ARV/0052
02 December 2019

**Planning Application – WA/104/19/HH
Southover, Avisford Park Road, Walberton**

The opportunity has been taken to review and an additional half metre has been added to the depth of the rear single storey extension, increasing it to 3.5m. Please therefore find herewith further amended drawings:

Ground and First Floor Extensions and Porch Site & Location Plans

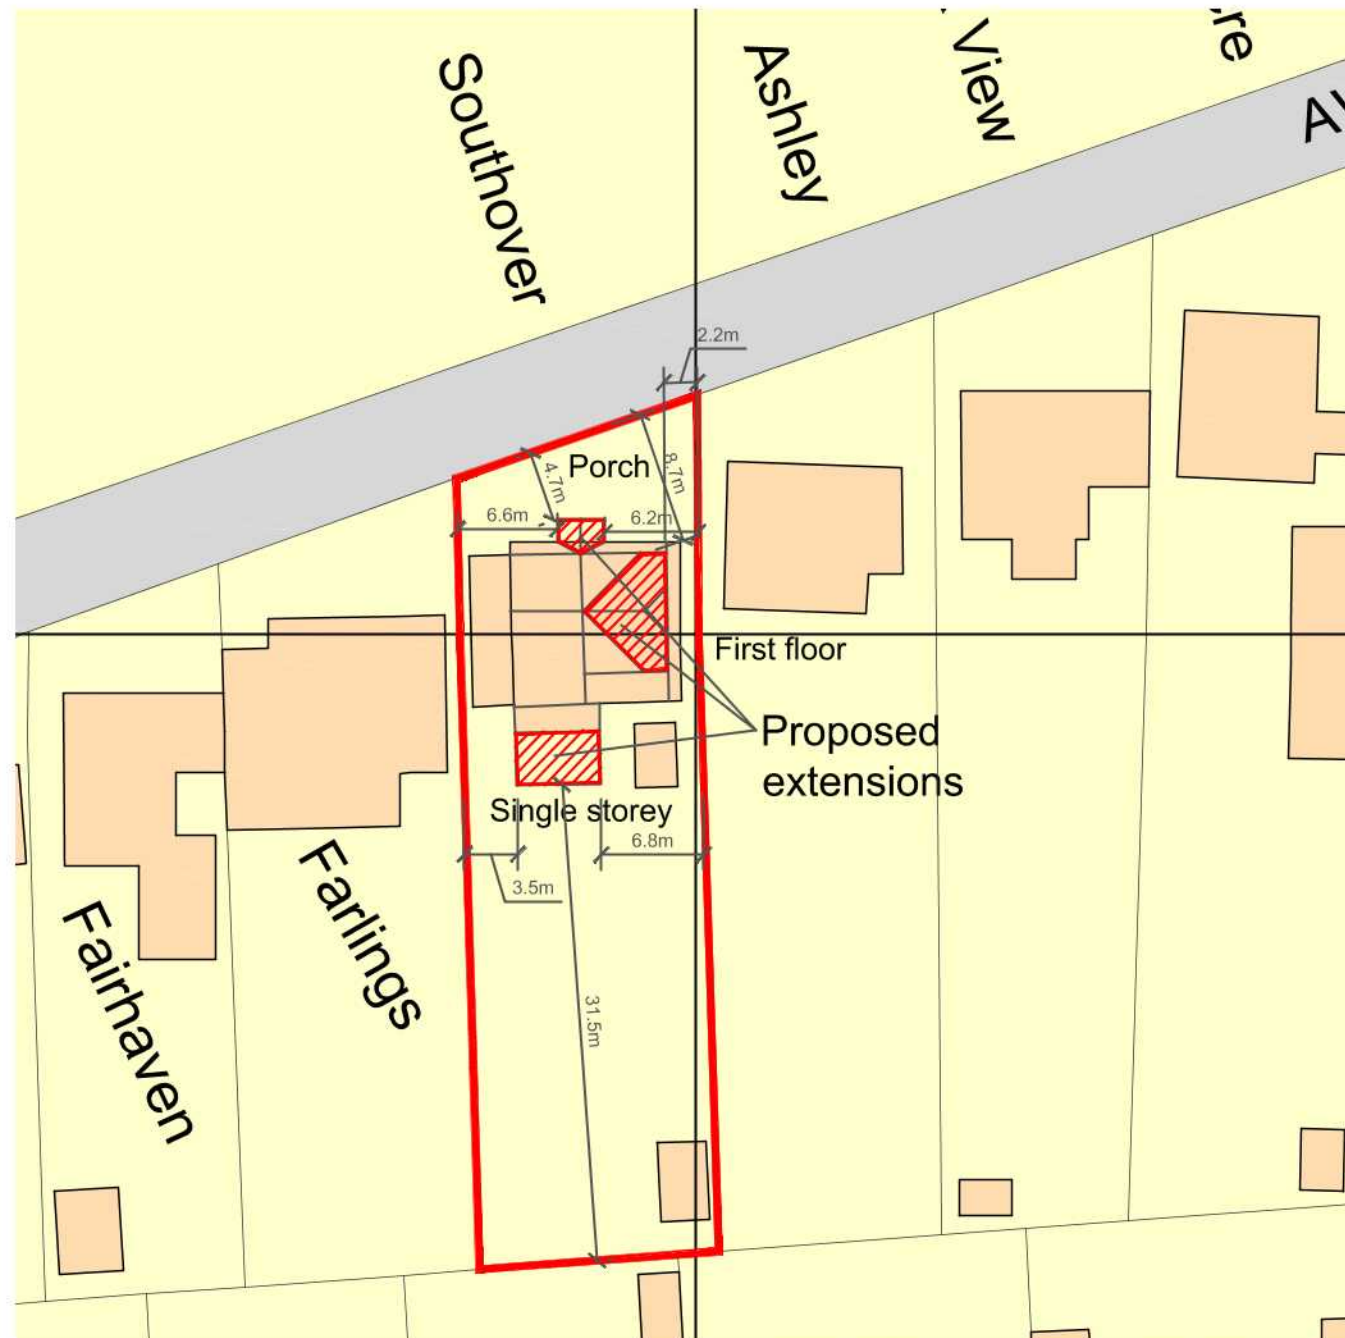
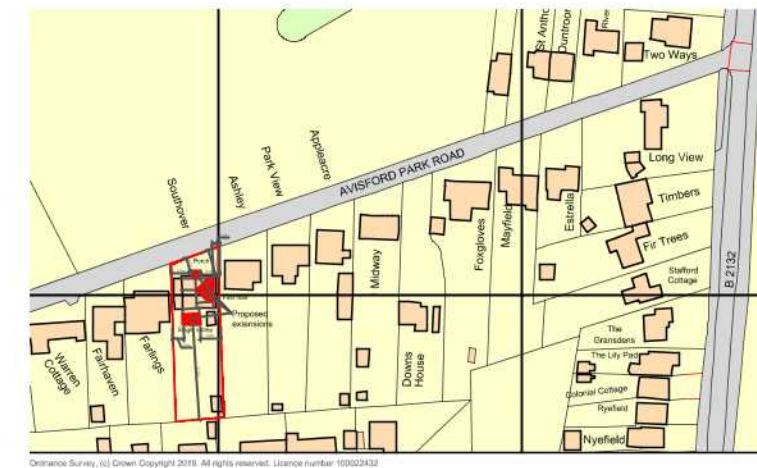
Please find attached an amended version of our site and location plan 0052/SL-30A with dimensions to the boundaries.
